Re: Objection to MP08\_0244 MOD 1 Modification Request for Mixed Used Development at 23-37 Lindfield Avenue and 11 Havilah Lane, Lindfield

As a resident of Lindfield, I/we wish to lodge an objection against the proposed Modification of the subject development based on the following grounds:

1 SHADOW DIAGRAM - 21stDEC_9AM
5003 SCALE1 : 650

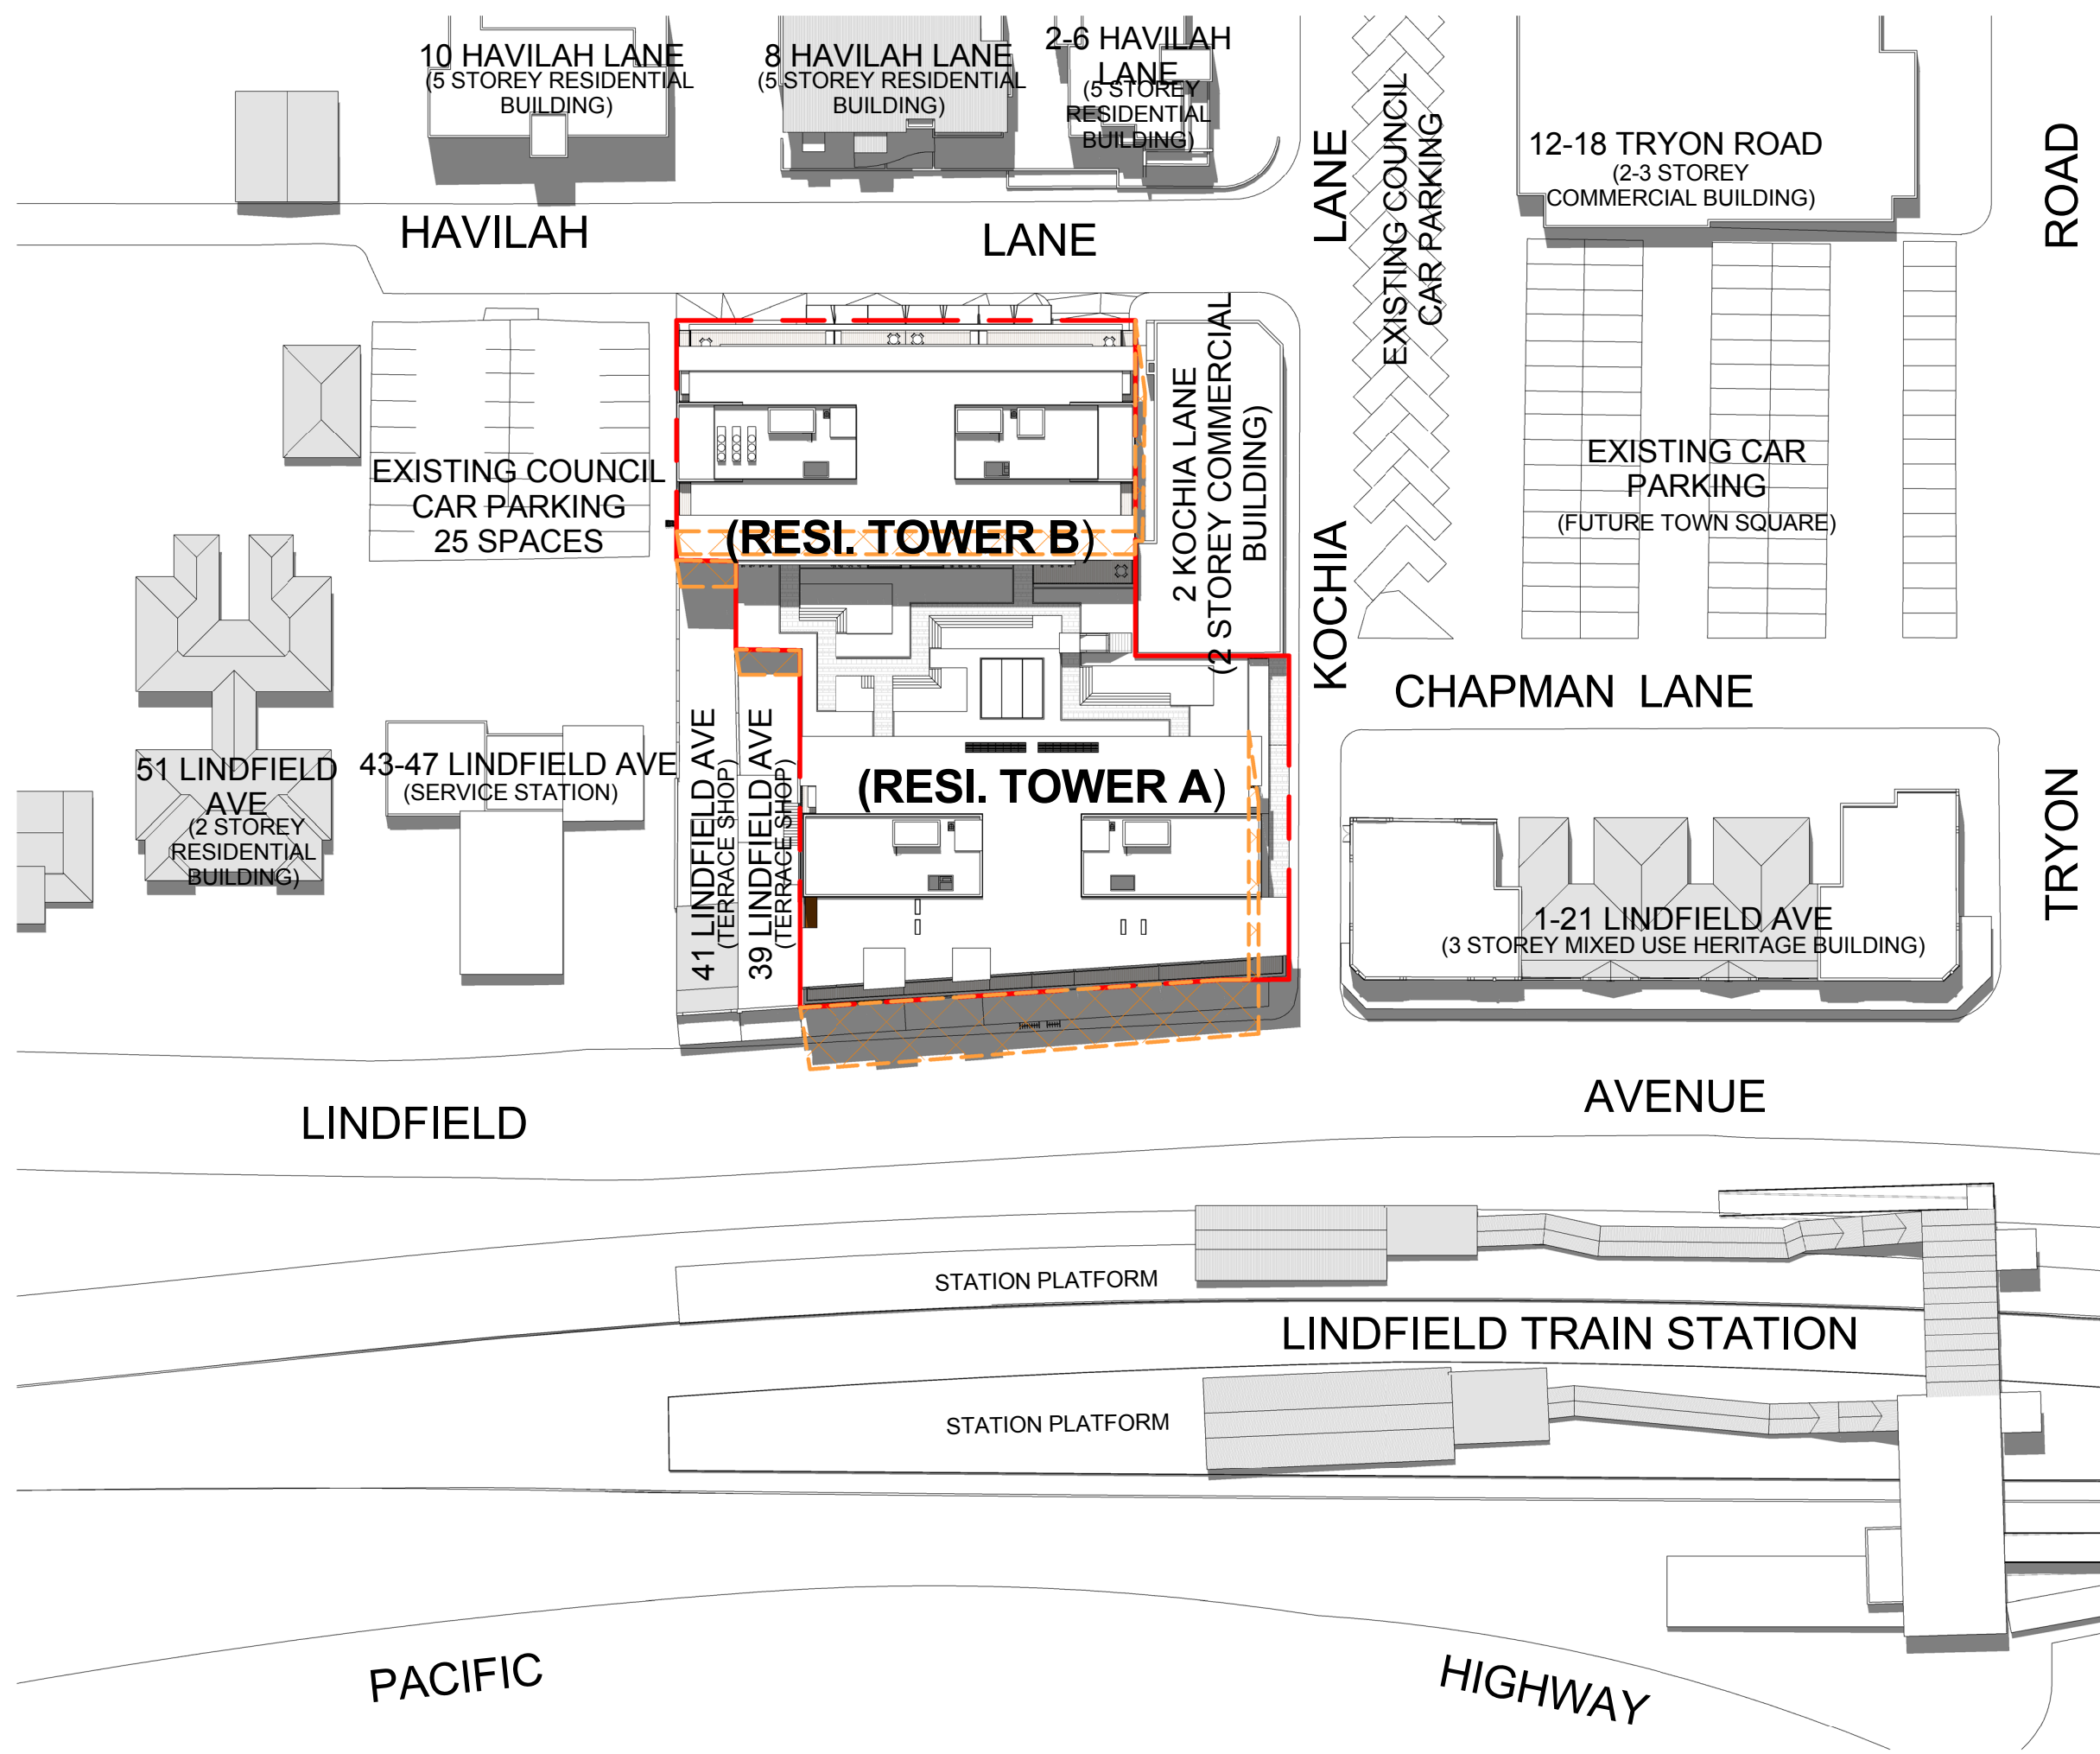
- The additional storeys create new adverse shadowing: a) for residents in the Havilah Lane apartments, particularly after 3pm b) for the popular outdoor café and central Lindfield hub area at 12 Tryon Road in afternoons, particularly in winter and c) for all commuters on the city bound Lindfield rail platform, instead of 50% of the year as approved, it will now be in shadow in the mornings 75% of the year
